Consultation Response from KC, Highways Development Management
2025/92020 2, Mount, Edgerton Road, Edgerton, Huddersfield, HD3 3AE
Change of use and internal alterations to dwelling (C3) to form supported living accommodation (C2) (Listed Building within a Conservation Area)
Date Responded: 12/11/2025 Responding Officer: D. Stainsby Responding Ref: K5-5NW/4

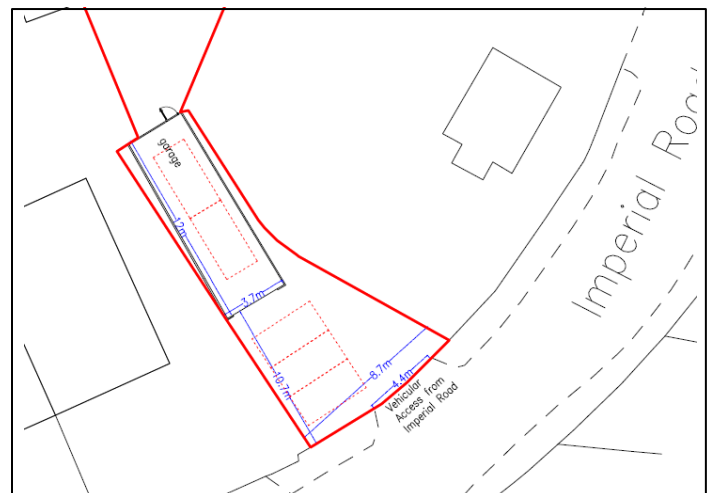
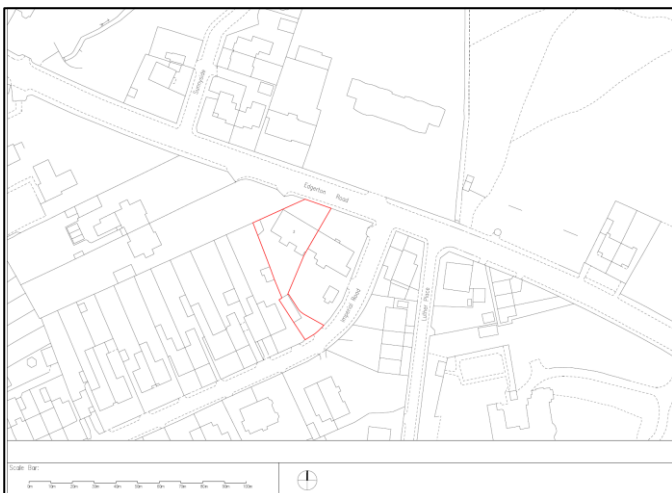
4 car parking spaces are available for the property which are sufficient for staff and visitor parking.

No cycle parking is proposed, and it is considered that secure cycle storage for staff and visitors should be provided

Secure cycle storage for staff and visitors should be provided
